5 July 2022

West Wyalong Solar Farm (SSD 9504) Development Consent Condition 8(a), Schedule 3 – Vegetation Buffer

I refer to your Request for Information (RFI) dated 24th June 2022 concerning the above following Lightsource bp's letter and supporting evidence by Lightsource's landscaping contractor (Hunter Land Management Pty Ltd - HLM) dated 27th May 2022 to the Department. Lightsource has requested the Secretary's agreement to vary Condition 8(a) of the Development Consent to allow the planting works for the vegetation buffer be delayed beyond the commencement of operations from November 2022 to April/May 2023 (Autumn).

Plan of Landscape Works

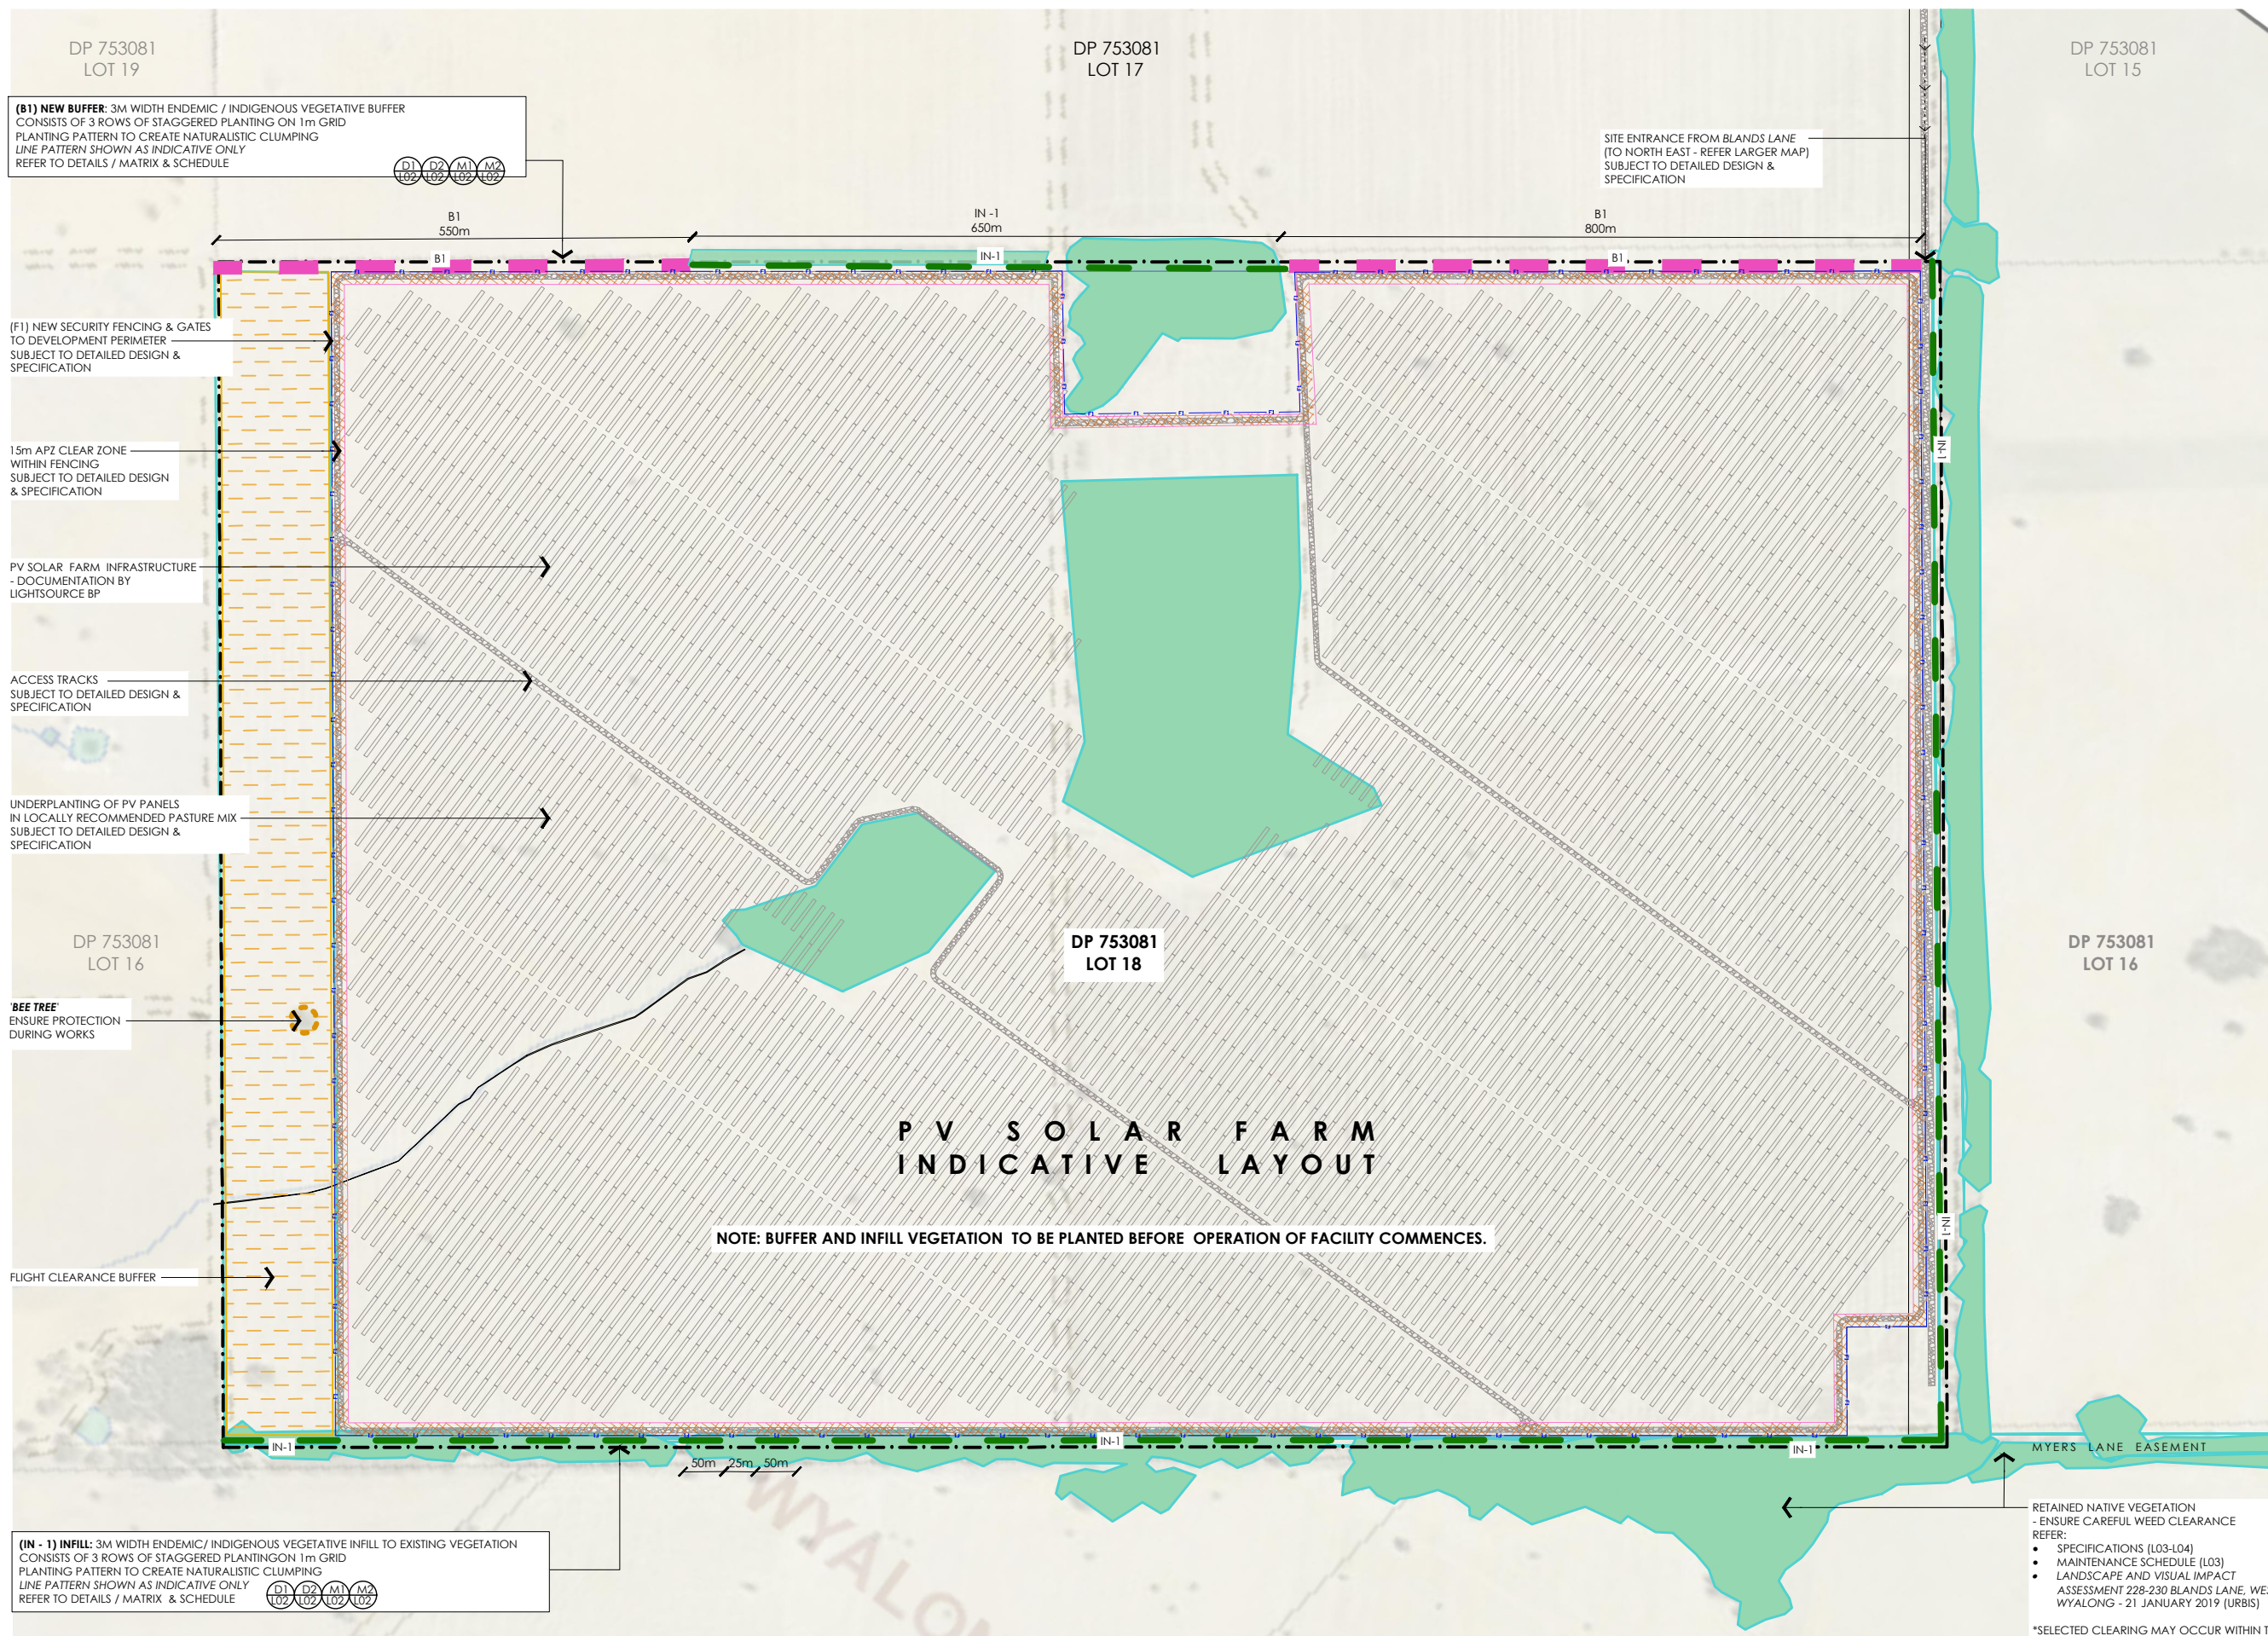
Please provide evidence that the delay in planting the vegetation buffer will not impact the establishment of the vegetation buffer within 3 years of the commencement of operation.

HLM advise the reason for the proposed delay in planting is based on the limited availability at local nurseries of the required amount of tube stock of the specific species for planting the vegetation buffer. Tubestock are typically grown in 40mm tubes and typically achieve a height up to 500mm before planting. HLM are instead proposing an "advanced tree planting" approach that will allow the tube stock to be grown in a controlled environment (frequent

watering and reduced exposure to heat and cold extremes) for a longer period off site. The resultant maturity of the tube stock in 150mm pots would be 20mm Diameter at Breast Height (DBH) and 1 – 1.5 metres in height. The delay in planting this tubestock after the November 2022 commencement of operations not only allows for larger tube stock size and a better landscape screening but also avoids the peak summer heat and before the winter frosts where risk of mortality is highest upon replanted tubestock.

HLM estimate that vegetation planted in Autumn 2023 (April/May) will be 3 metres in height with a DBH of 100mm in November 2025 (3 years from commencement of operations in November 2022).

Based upon the advantages of the advanced tree planting approach described above, the Secretary can be satisfied that Lightsource's request to delay planting of vegetation after development commencement will not impact the establishment of the vegetation buffer within 3 years of the commencement of operations.
